Glyn Rhonwy Pumped Storage System – project update

File reference EN010072

Meeting with Snowdonia Pumped Hydro Limited (SPH)

Feedback on draft application documents and project update.

Land Plans: Sheet 2 (Revision 1)

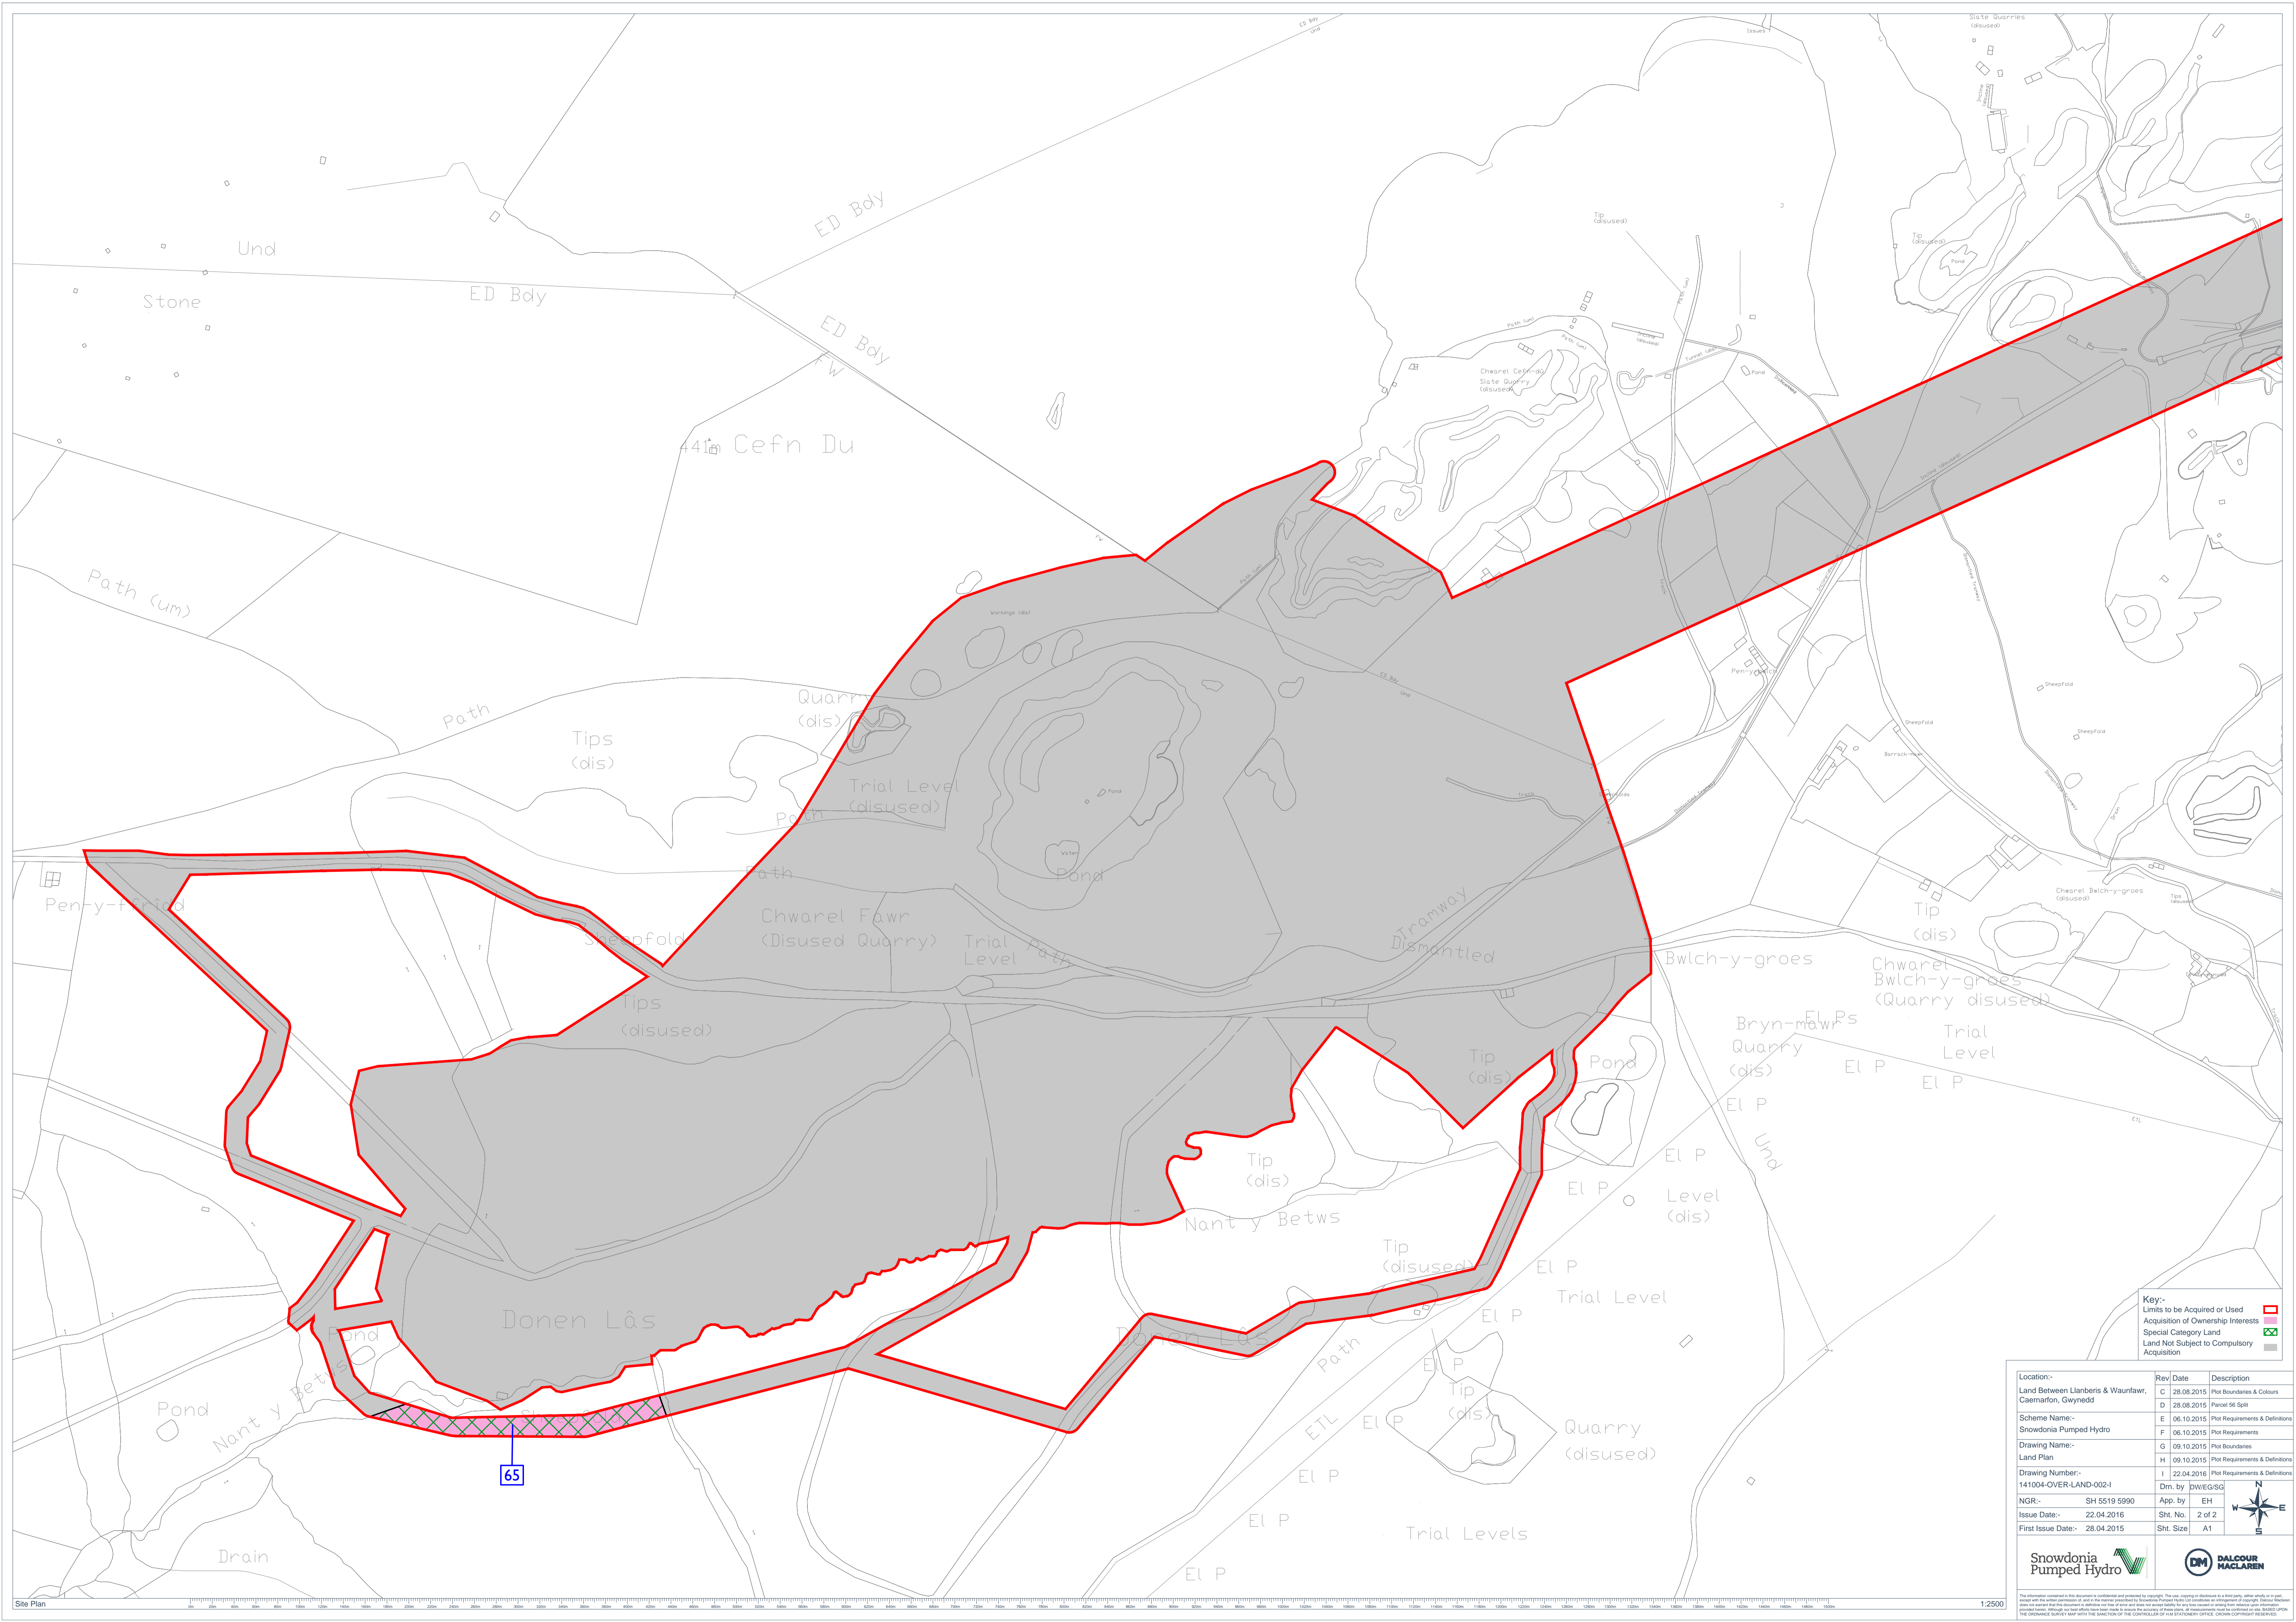
Land Plans:

• The key states that 'temporary occupation' is being applied for over the land, but there is no such power in the DCO.
